Address: 40 Thornton Lodge Road Huddersfield hd1 3jh

Application number: 2024/90706	
What is the application for?:	Prior approval for enlargement of dwellinghouse by erection of additional storey
Address of the site or building:	38, Thornton Lodge Road, Thornton Lodge, Huddersfield, HD1 3JH
Postcode:	HD1 3JH

Type of comment: An objection	
Do you wish your comments to be published on the website anonymously?	No

EXISTING SIDE ELEVATION FROM NO 40.
SCALE 1:100.

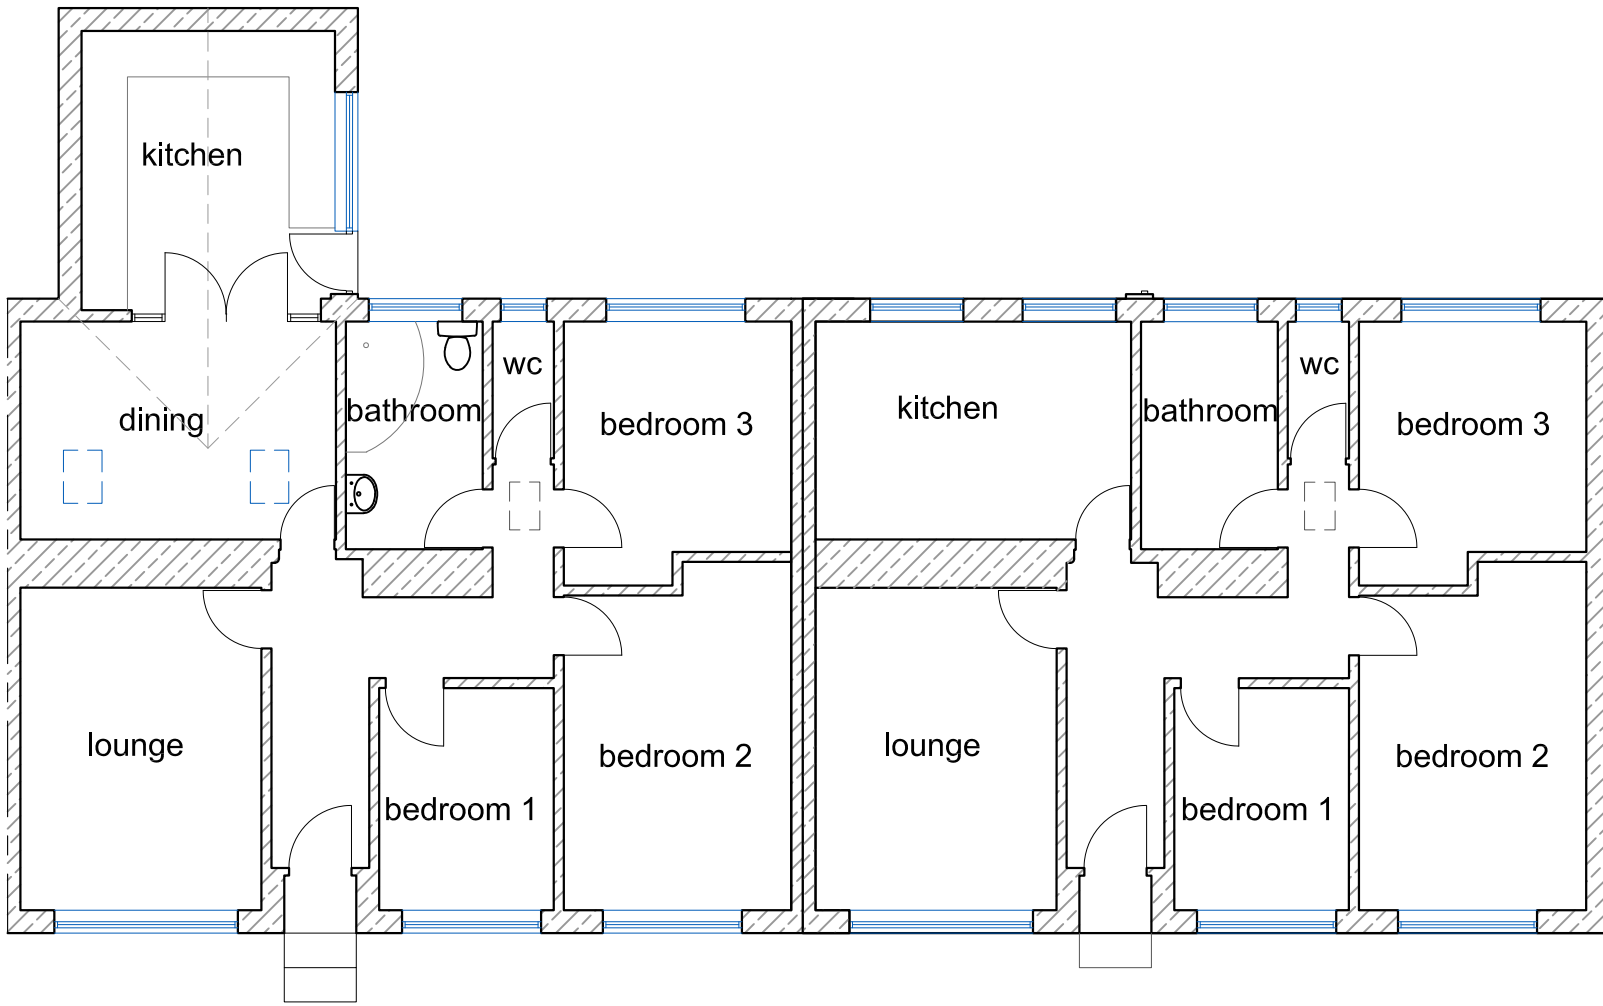
. Half of the applied erection for the house, 38 (2024/90706) Thornton Lodge Road, would be overlooking and intruding onto 40 Thornton Lodge Road property, garden both at the front, rear, on that road and on houses, gardens, adjacent. It would be invasion of privacy and a sense of overpowering on the bungalows at either side of the house number 38 (2024/90706). What also should be taken into account is the design guidelines of the bungalows and the beautiful aesthetics of house numbers 36, 38 and 40 Thornton Lodge Road at present day now and what they would look like after the additional storey extension.

If house number 38 (2024/90706) was erected with an additional storey then height would be increased, due to this , the 45 degree line would be affected and there would be a massive reduction of natural light going into the habitable areas of the bungalow number 40. The kitchen, bathroom and bedrooms would be dark, imposing and have a negative effect.
